From: Martyn White <Martyn.White@arun.gov.uk>
Sent: 22 October 2021 16:24
To: Planning.Responses <Planning.Responses@arun.gov.uk>
Cc: Simon Davis <Simon.Davis@arun.gov.uk>
Subject: A/197/21/PL

A/197/21/PL

Stitches and Frames, The Square, Angmering, BN16 4EA

Change of use of vacant retail shop to restaurant to include the installation of new kitchen extraction system, AC condensers, new windows, awning, planters. This application affects the character & appearance of the Angmering Conservation Area & is in CIL Zone 2 (Zero Rated) as other development.

Drawing SHOPFRONT ELEVATION AND SECTION AA PROPOSED			
Drawn	Date	Scale	
JB	AUGUST 2021	1:50 @ A1 1:100 @ A3	
Job No.	Drg. No.	Rev.	
2111	P200	#	
Drawing status PLANNING

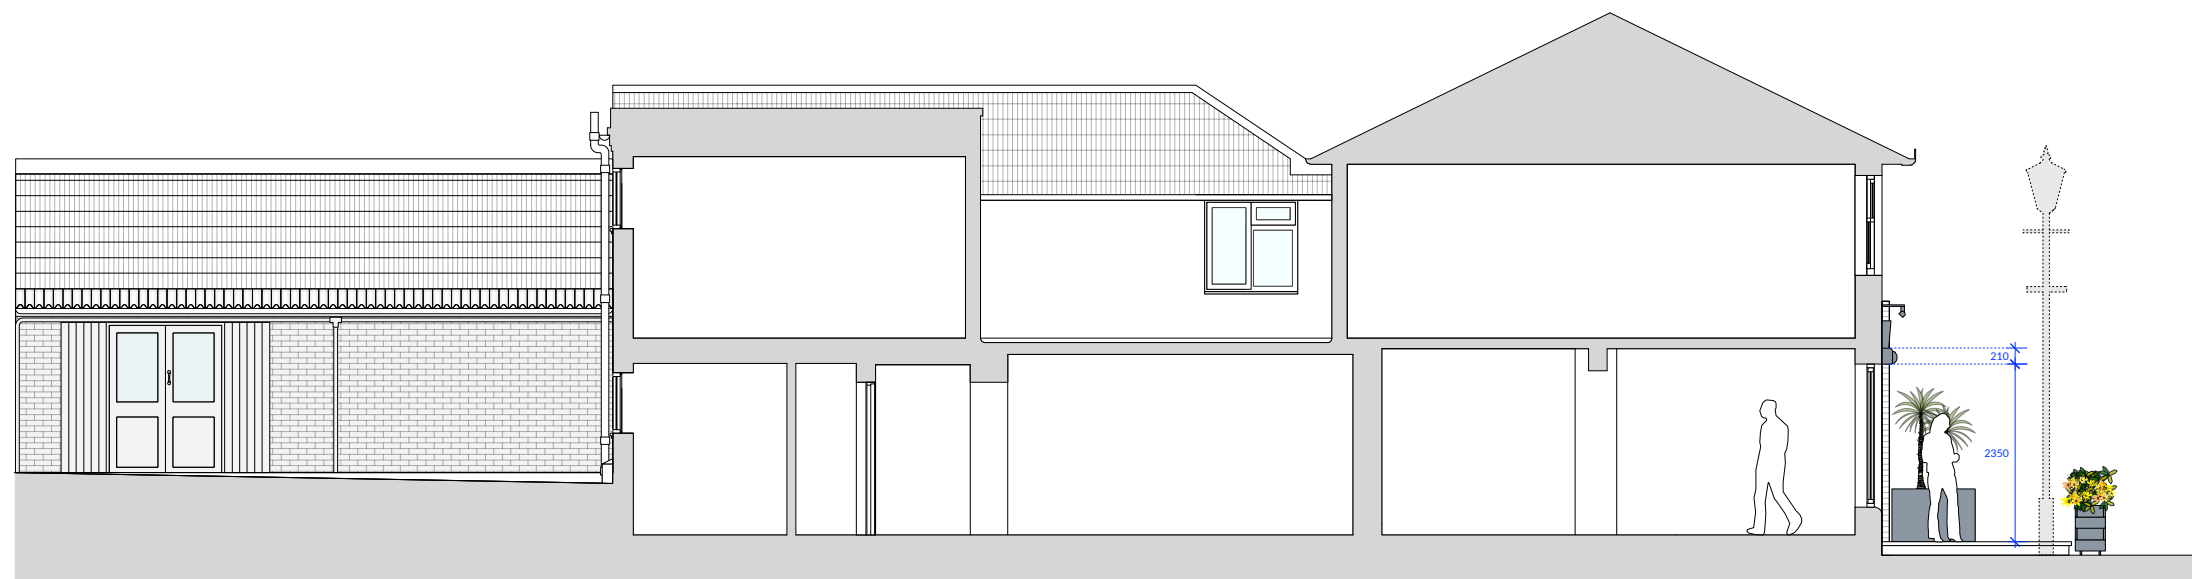
The existing shopfront runs across two thirds of the ground floor of the building, with the remainder being occupied by an estate agency. The existing fascia signage board appears to be printed acrylic panels, running across the full width of the shop. The heritage statement identifies that a surface mounted conduit and projecting arms above indicate that the signage has been illuminated in the past, but that the lights no longer appear to be functional. Of note is the fact that the neighbouring estate agents' signage board is illuminated by a linear LED. It would appear that the proposal is to:

- Remove the existing fixed timber shopfront glazing and replace it with painted timber framed sliding folding windows
- remove the existing fascia sign and replace it with a hand painted timber signage panel (with 'new warm white linear LED lighting'),
- introduce a hanging sign at the northern end of the Fascia signage (to hang centrally on the existing brick pier at the end of the façade),
- erect a new awning

Overall, the proposed shop front would look very similar to the existing one. The main difference being the introduction of the sliding, folding windows, which would operate and appear differently to the existing ones. The use of timber for both the windows and fascia sign is positive as it will ensure that a material appropriate for the conservation area remains. Whilst the colour is not one that I would associate with a conservation area, I believe that if carefully selected would have a neutral impact. The proposed fascia sign is similar to both the existing one and that used for the neighbouring estate agents (in terms of dimensions) and does not look out of place. Overall, I believe that the alterations will have a neutral impact and are acceptable as a result. You might wish to request details of the sliding folding windows so as to be sure of the detailed design and confirm the glazing details. However, this can be provided for by way of condition. Likewise, it might help to view the RAL colour the shop front would be painted.

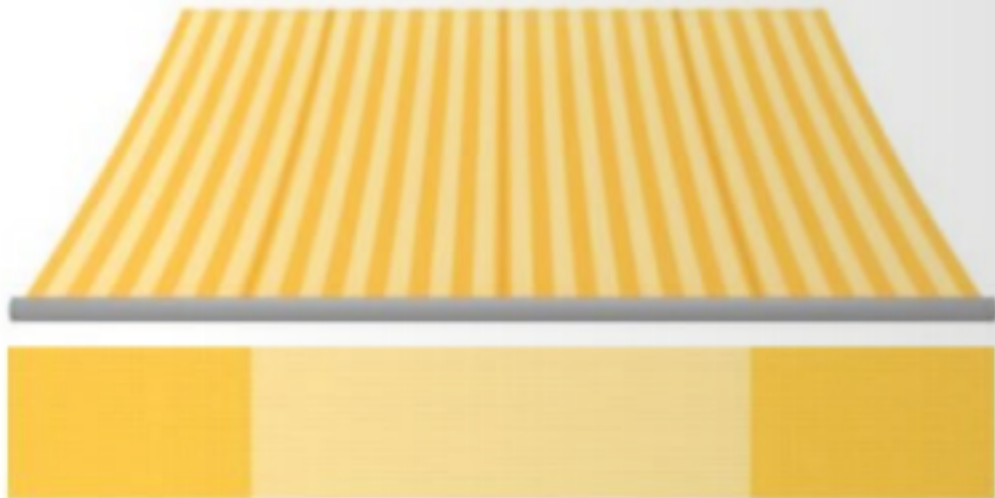
The proposed awning is to be face fixed to the lower edge of the signage panel. I note that one has recently been granted consent at a nearby unit, and that there are some others in The Square. As a result, it will not be out of character, and is acceptable.
